**A30 Chiverton to Carland Cross
TR010026**

**8.24(A) REQUEST FOR NON-MATERIAL
AMENDMENTS TO THE DRAFT DCO**

July 2019

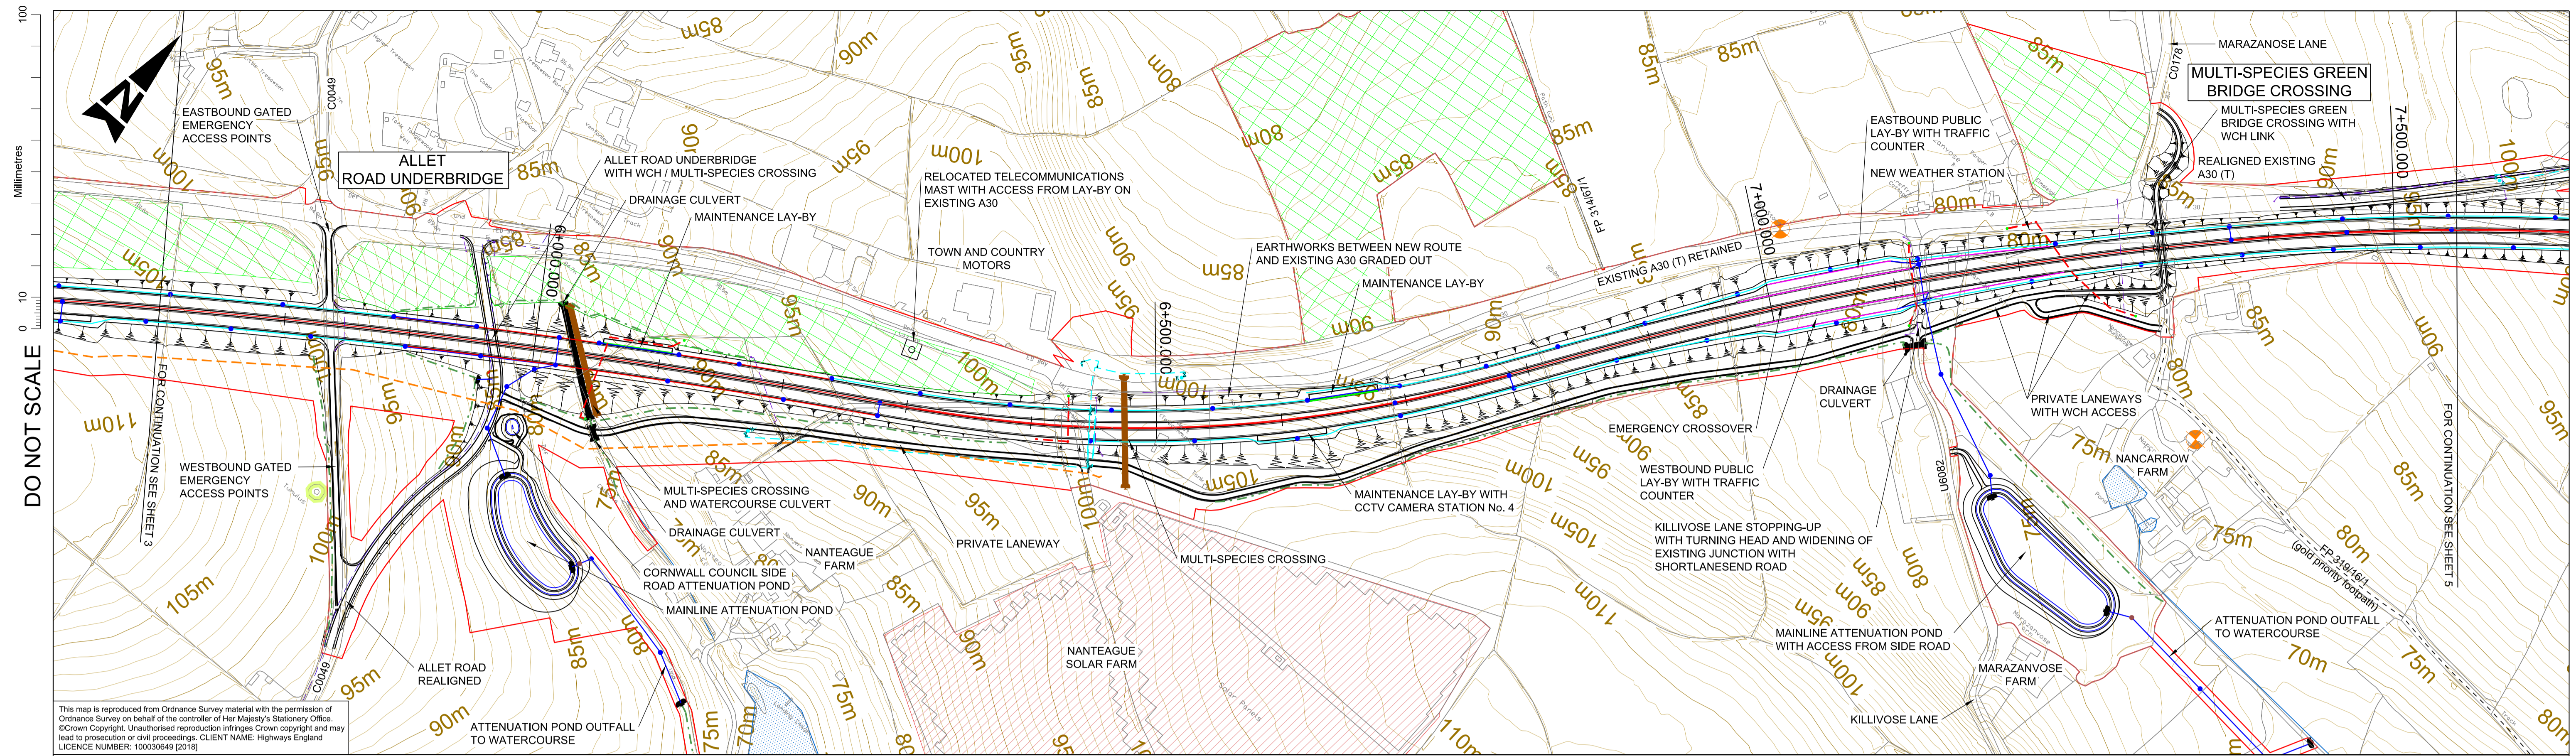
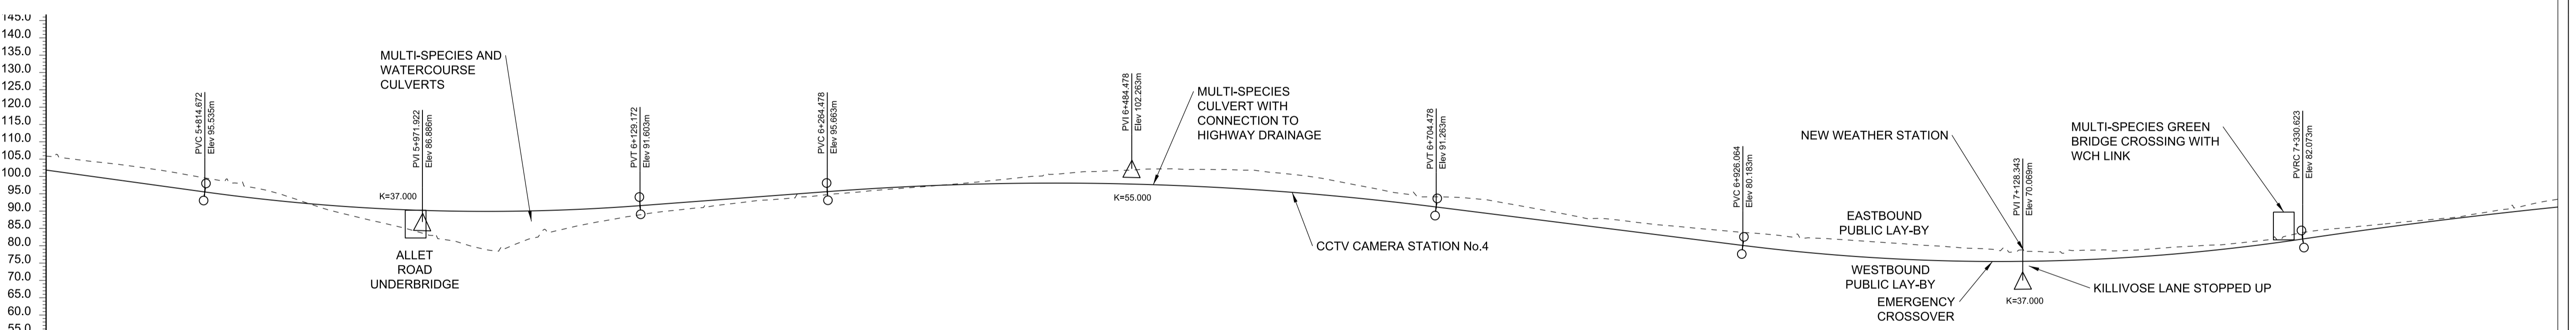
1.1.2 Following ongoing engagement with EE and the other parties with an interest in the land affected by the previous change a new location for the mast is now proposed in an area to the north east of the existing mast, with access from the existing A30. This is shown on Sheet 4 of the **General Arrangement and Section Plans** (Document Reference 2.6(C)).

2.5(C)	Rights of Way and Access Plans, Sheet 4	Reference 27 has been moved to show the private means of access for the relocated mast.
2.6(A)	General Arrangement and Section Plans, Sheet 4	The position of the relocated mast has been amended on the plan and annotation labels have been moved.
